**Planning Application No: 3/2025/0046**

**Proposal: Proposed demolition of existing conservatory and replacement with single-storey side garden room. Erection of Flag Pole.**

**Location: Cut Thorn Farm Shire Lane Hurst Green BB7 9QR**

Proposed garden room extension to side to replace existing conservatory
for Mr & Mrs. J. Cannan
Cuf Thorn Farm, Shire Lane, Hurst Green
drawn by Artech Design 01772 456592
drawing no. 1N/3077/2 Scale 1:50

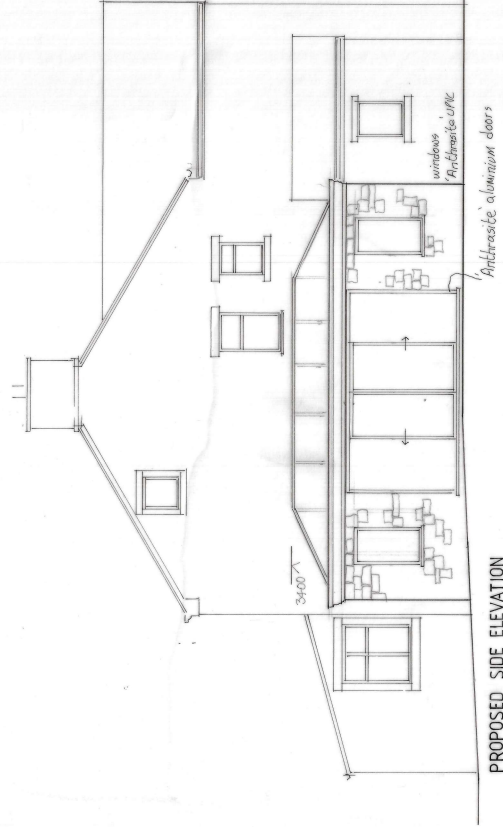
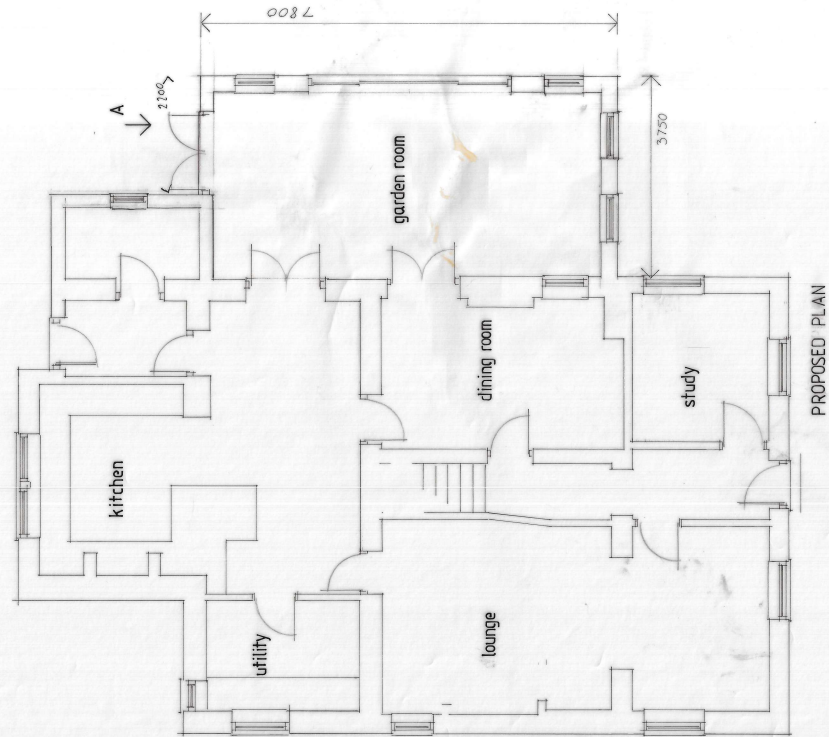
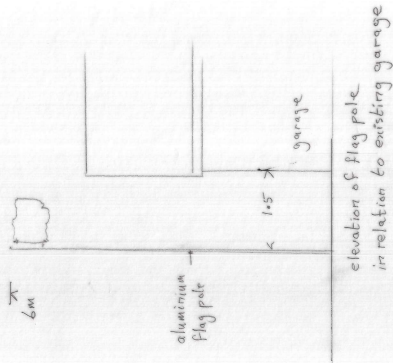
There is no objection to the proposal of the single storey side garden room to replace the existing conservatory.

With ref. Heritage Statement submitted, *'a new flag pole to be erected to the left of garage. The proposed flag pole is to be positioned 1.5m to the left of the garage and 1.5m from the north boundary and is for personal use only'*

There are no details relating to the size of the flag to be mounted on the pole, however due to the location of the pole it is not anticipated to interfere with the highway, therefore there is no objection on highway safety grounds.
